Emirates Resort, Wolgan Valley – MP06_0310-Mod-4 Helicopter Flight Path and Numbers

The Wolgan Valley Association (the WVA) objects to the proposal by Emirates Hotels (Australia) Pty Ltd to increase helicopter flights into the Wolgan Valley Resort from 14 helicopter flights per week to 105 helicopter flights per week (or a maximum of 15 trips per day), until 2 wheel drive access is restored to the Valley and then dropping to 50 trips a week (or a maximum of 10 trips per day), as well as the proposal to change the flight path.

Figure 3. Preferred flight paths.

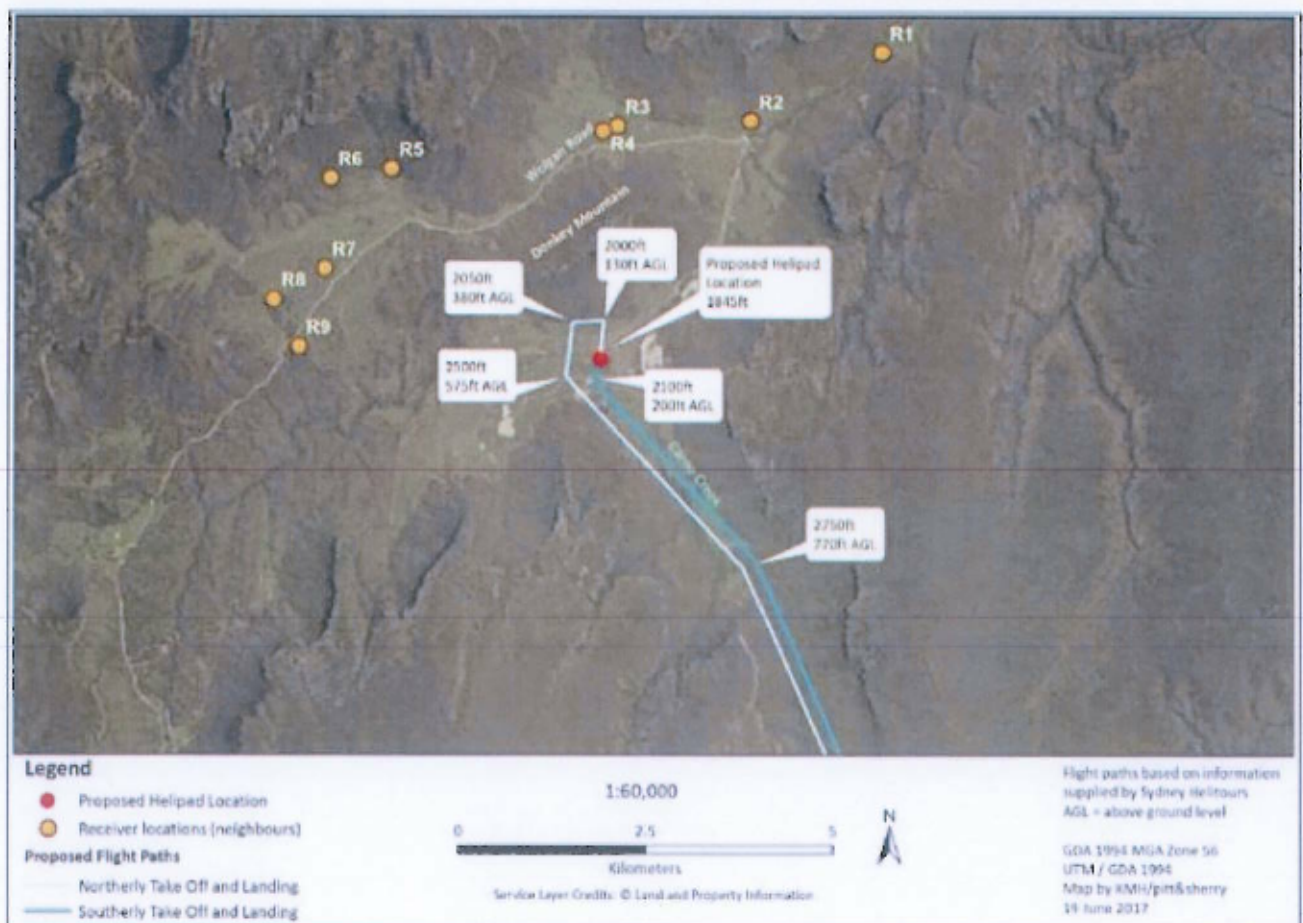
The third comment is that the change of flight path away from Carne Creek results in more direct impact on the residents of the Valley. While we understand that this may be preferred as a means of protecting the Gardens of Stone State Conservation Area and Wollemi National Park, it will mean that residents are exposed to noise levels well beyond what they have experienced over the last 20 years.

In relation to the 2023 proposal (Mod-3 Withdrawn), we note that it involved significantly less concern at that stage on account of the measures being temporary only (ie no component of the proposal seeking a permanent increase) and following a flight path up Carne Creek, away from the Valley residences. Since that time, the current proposal changes the flight path and proposes the permanent increase from 14 flights to 50 flights per week.
